# A47 Blofield to North Burlingham

**Scheme Number: TR010040**

## **9.16 Request for a Non-Material Change to the Application**

September 2021

Drawing Number	Rev
Highways England PIN	
HE551492-	P05
GTY-LLO-000-DR-BL-00005	
Location

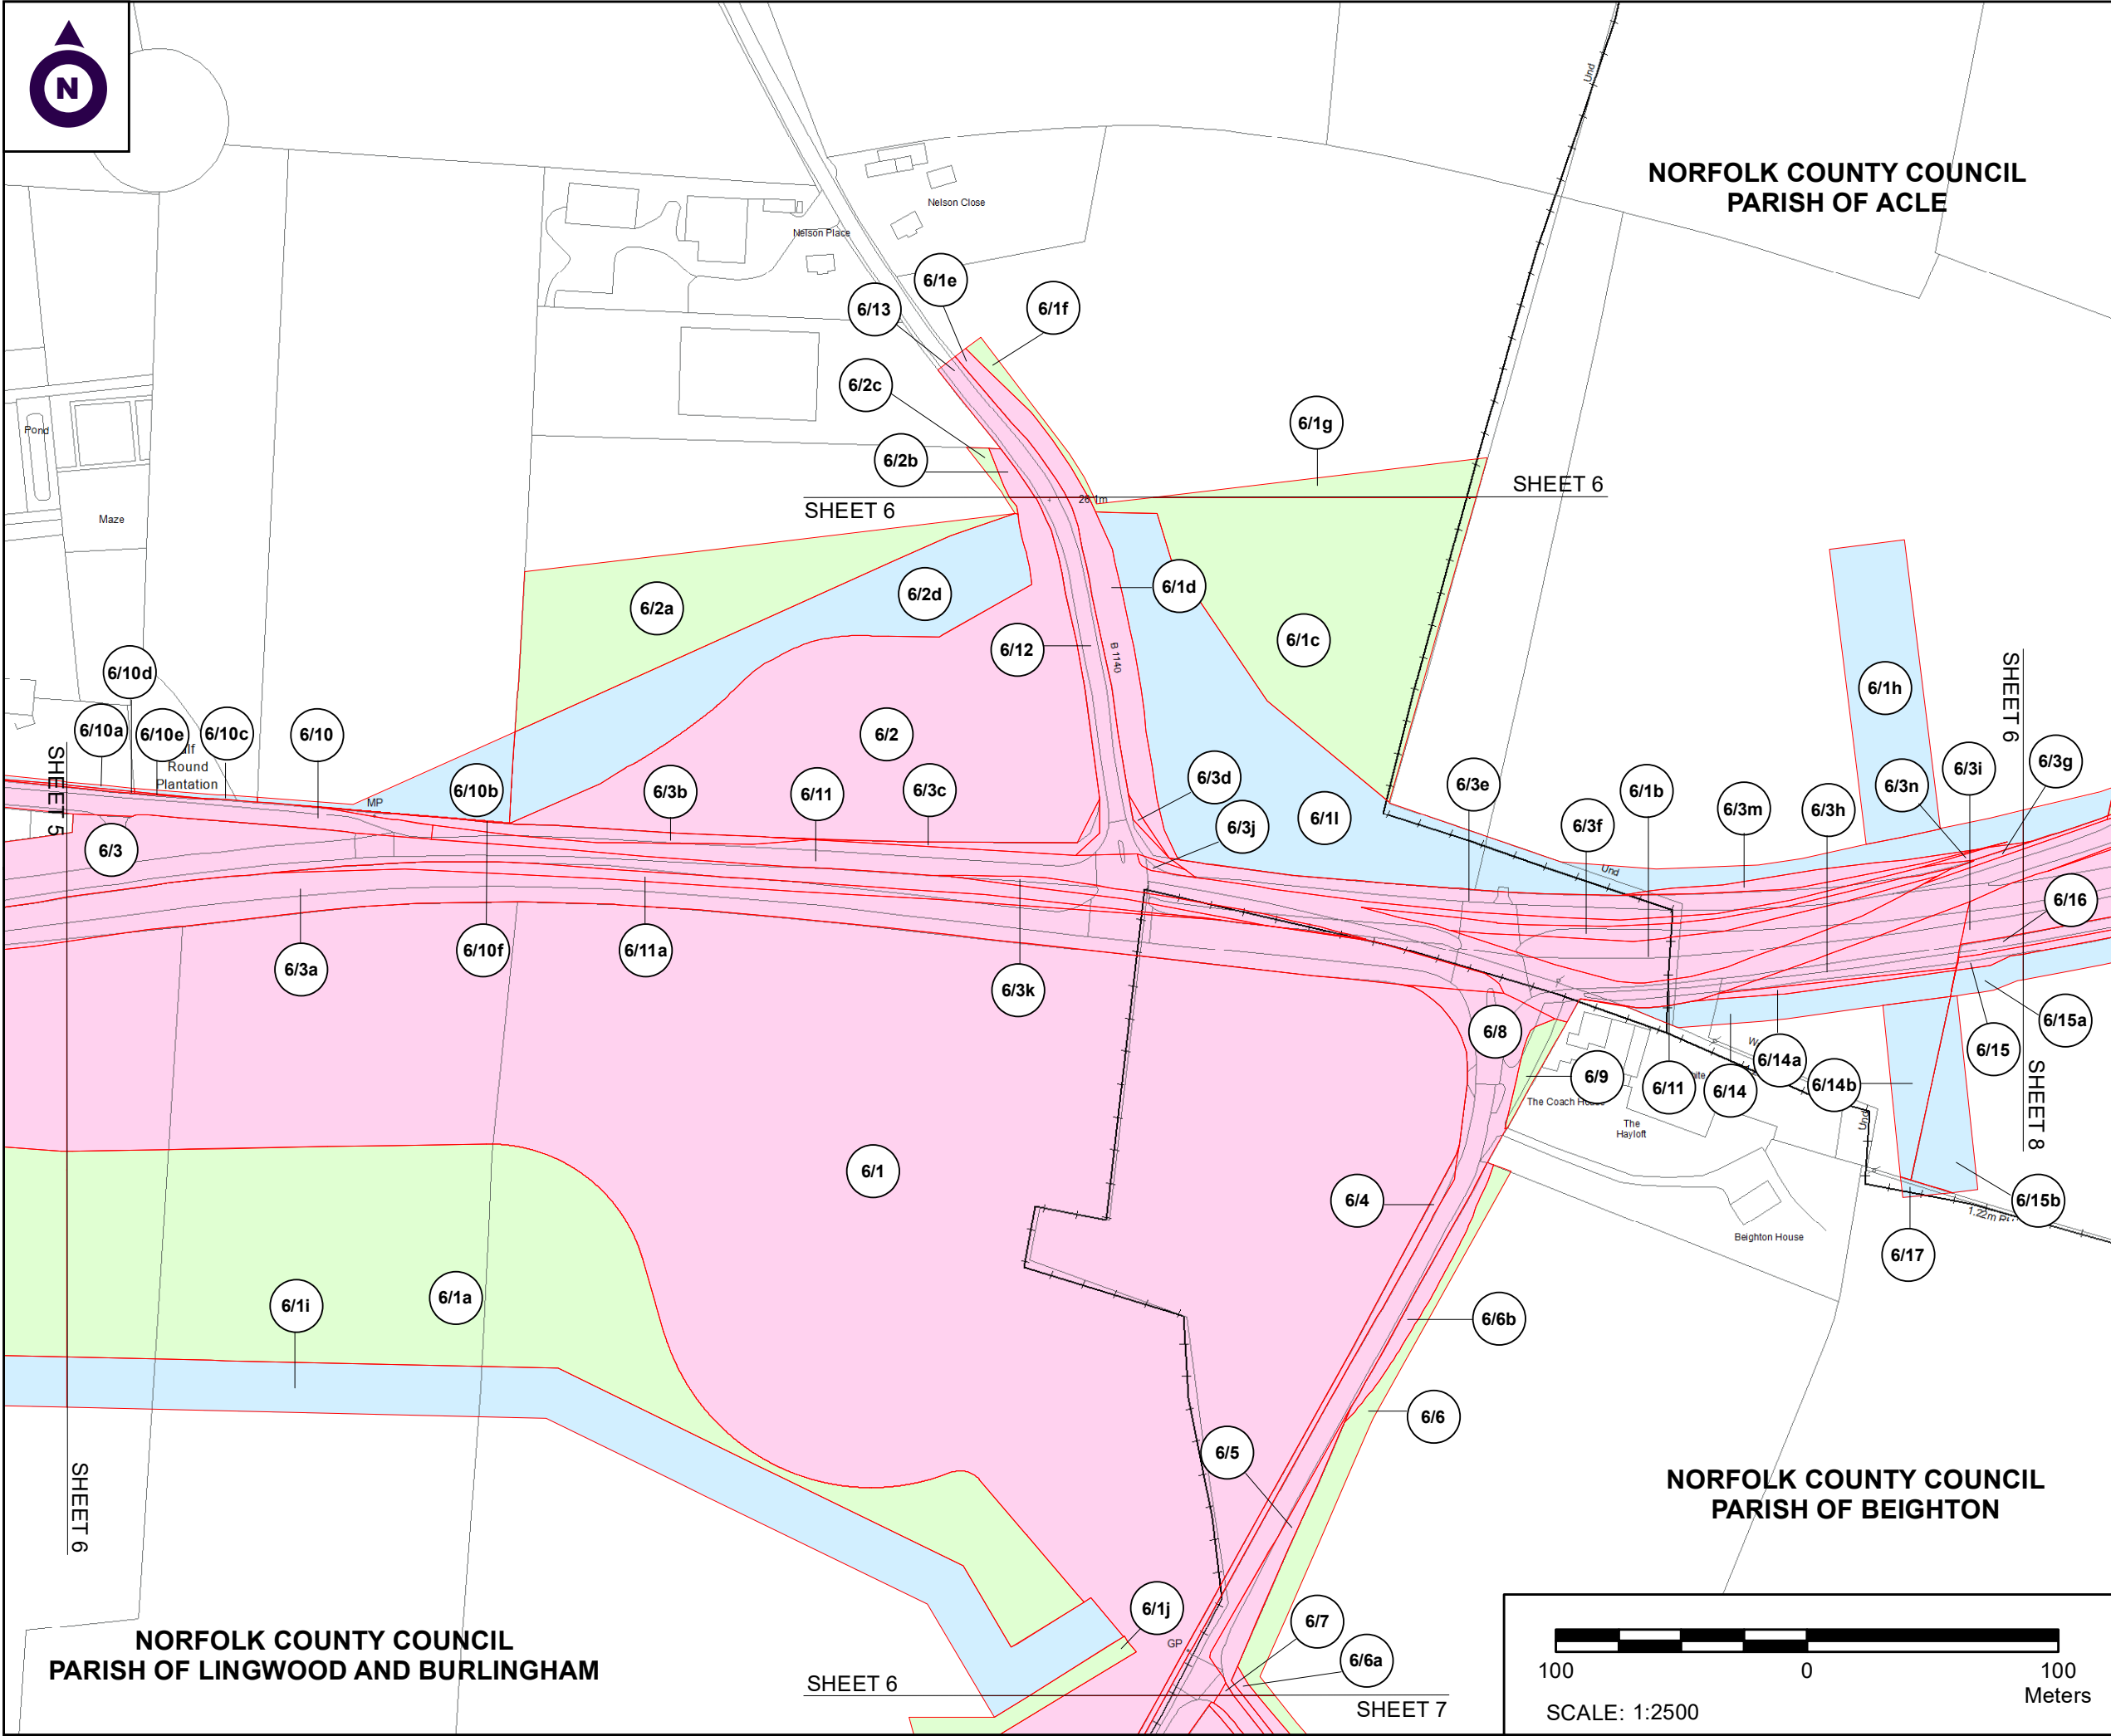
- 2.1.2 The Applicant has provided the above documentation to effect a proposed change relating to the re-provision of an existing block valve site (Existing Block Valve Site) belonging to Cadent Gas Limited (Cadent), which is situated adjacent to and to the south of the current A47. The Existing Block Valve Site is shown on sheet 5 of the Land Plans as plot 5/2 (**TR010040/APP/2.2 Rev 1** submitted at Deadline 4).

- 2.1.5 To allow the provision of the New Block Valve Site, a new permanent acquisition plot (plot 5/1e) has been added to the Land Plans (**TR010040/APP/2.2 Rev 1**) and the Book of Reference (**TR010040/APP/4.3 Rev 4**) on land for which temporary possession was previously sought. It is anticipated that this land would be vested in Cadent after completion of works. The extent of this plot reflects the limits of deviation for Work No.5, and a degree of uncertainty as to the precise location of the North-South Gas Main (historical records as to the location of the apparatus of statutory undertakers is generally imprecise).

- 2.1.6 In addition to acquiring the New Block Valve Site, it will be necessary to provide a replacement access to the New Block Valve Site (Replacement Access). The Existing Block Valve Site is accessed directly from the existing A47, however this will not be possible for the New Block Valve Site. It is therefore proposed to provide a new access track, leading south from the access track included in Work No. 23. New rights will be required for the new access track between Work No.23 and the Diverted Gas Main, and this has necessitated the creation of a new rights plot (plot 5/1b). Although the description of Work No.5 does not need to change, the limits of deviation for Work No.5, shown on sheet 5 of the Works Plans (**TR010040/APP/2.3 Rev 1**) need to be amended to take into account the land on which the Replacement Access is to be provided.

- 2.1.7 Finally, the new access track will need to provide sufficient room for van and trailer to turn around. As a result it is necessary for the access track to continue over the line of Work No.5 as far as the Order Limits. This land will remain "blue" land (limited to the acquisition of rights), however in addition to the rights to install and keep the Diverted Gas Main in the land, access rights will also be required over the land. As a result a new rights plot (plot 5/1g) has been added to the Book of Reference (**TR010040/APP/4.3 Rev 4**) and the Land Plans (**TR010040/APP/2.2 Rev 1**).
